From: ENVU Biodiversity and Land Use
Sent: 10 November 2025 14:53
To: Planning ContactCentre
Subject: 2025/92776 at location land at, Eastfield, Shepley, Huddersfield, HD8 8HB

Please see ecological commentary below:

Figure I. Site Plan

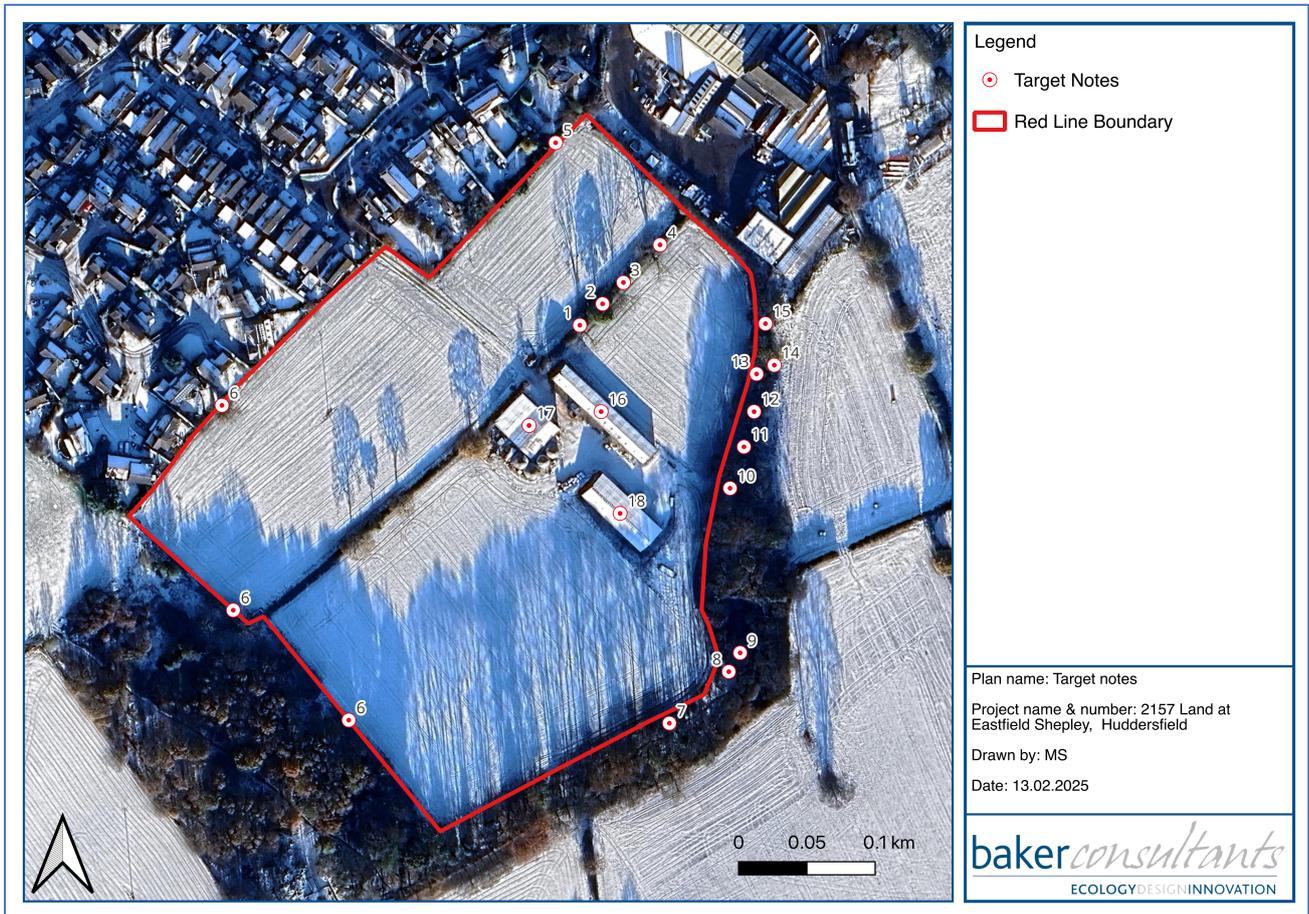
- Bats - Prior to any demolition of the farm buildings (B1–B3; TN16–18) as they were observed to have low potential for roosting bats – this will need to be completed prior to determination under case law (CO/2820/2008 / 2009 EWHC 1227(Admin)).
- Bats – trees surveys for T1, T3 and T4 should they require felling or pruning as they were observed to have potential for roosting bats
- Badgers - A pre-commencement badger survey is recommended to update the badger status on site. This will be conditioned.

Bat surveys for the farm buildings (B1–B3; TN16–18) and T1, T3 and T4 (should they require felling or pruning) will need to be completed prior to determination under case law (**CO/2820/2008 / 2009 EWHC 1227(Admin)**).
